Thurrock Flexible Energy Centre (EN010092)

Gravesham Borough Council

Deadline 4

Comments on document EN010092-001245-Thurrock Power Ltd responding to our Deadline 2 submission to which the paragraph and page references refer

Figure 4.2: Annual-mean NO₂ Concentrations at GR13 ($\mu\text{g.m}^{-3}$).

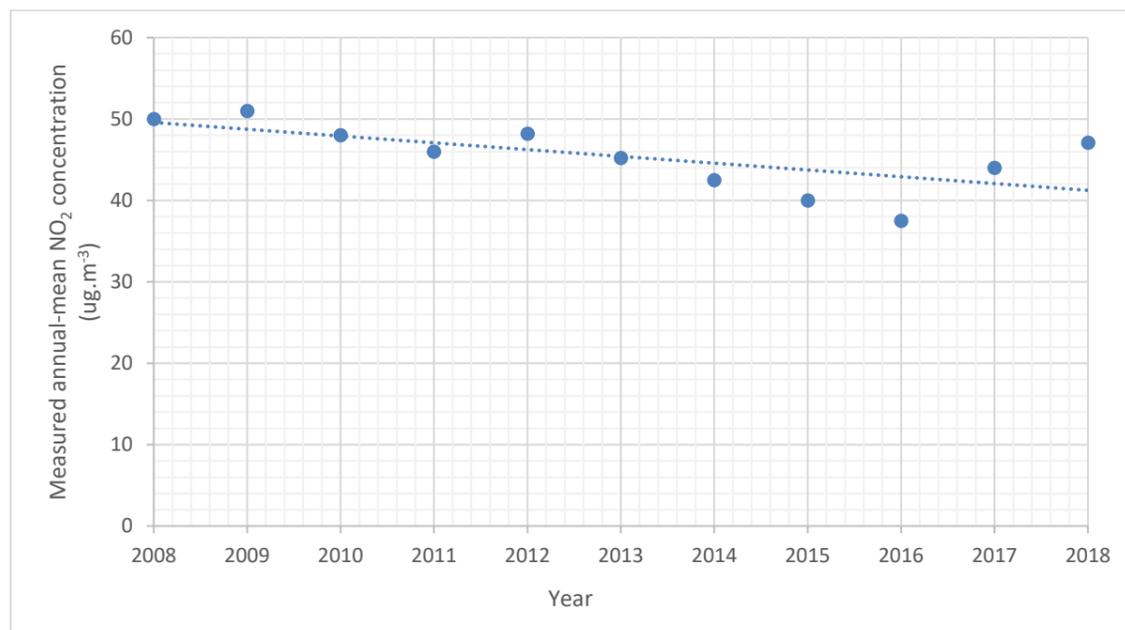
<p>Further advice has been sought from the consultants taking into account the questions posed in ExQ1 to the applicant: 1.1.3, 1.1.4 and 1.5.7.</p> <p><i>1.1.13 Explain the adverse impact on air quality at receptor 9 – Gravesend one way system.</i> BV comment that “additional work including modelling of additional receptors around ‘Receptor 9’ and GR13 (West Street) has been completed by the applicant in appendix 12.8. This additional work confirms that the AQAL is predicted to be exceeded at receptors adjacent to West Street as a result of the development (Paragraph 1.3.11 of Appendix 12.8). This is true in both the 2022 and 2025 modelled scenarios. This is as a result of the effect of traffic emissions and process contribution from the proposed development. Without the development in place the pollutant concentration at these receptors is above 40ug/m³. Given that the sensitivity of the site increases at higher pollutant concentrations, the effect is</p>	<p>Appendix 12.8 notes that in 2025 concentrations at West Street are predicted to exceed the Air Quality Assessment Level (AQAL) with or without Thurrock FGP. The existing background concentrations and traffic on the Gravesend one-way system (designated in 2005 due to elevated NO₂ levels from traffic) remain the major sources of elevated concentrations at West Street. Para 1.3.1 of Appendix 12.8 describes the small contribution from Thurrock FGP, a predicted NO₂ increase of 0.6 µg.m⁻³ at West Street. This is only 1.5% of the AQAL of 40 µg.m⁻³ and 1.3% of the cumulative predicted environmental concentration (PEC) of 44.9 µg.m⁻³ predicted in 2025 at GR13. The small incremental contribution that is emissions from Thurrock FGP will indeed be controlled at source: an air pollution control (APC) system will be used to control emissions at source to ensure that the emissions limits set out in the Industrial Emissions Directive, and</p>	<p>It is accepted that emissions will be controlled at source, though the effect of these controls has not been quantified and the results presented in the assessment still show that there would be a ‘moderate adverse’ effect at GR13 as a result of Thurrock FGP in 2022 in line with the IAQM guidance.</p> <p>As above, as emissions from traffic are expected to reduce, clarification is sought as to the increase from 2018 of 47.1µg/m³ to 2022 of 48.4µg/m³ modelled concentration at GR13 and other modelled increases between 2018 and 2022.</p>
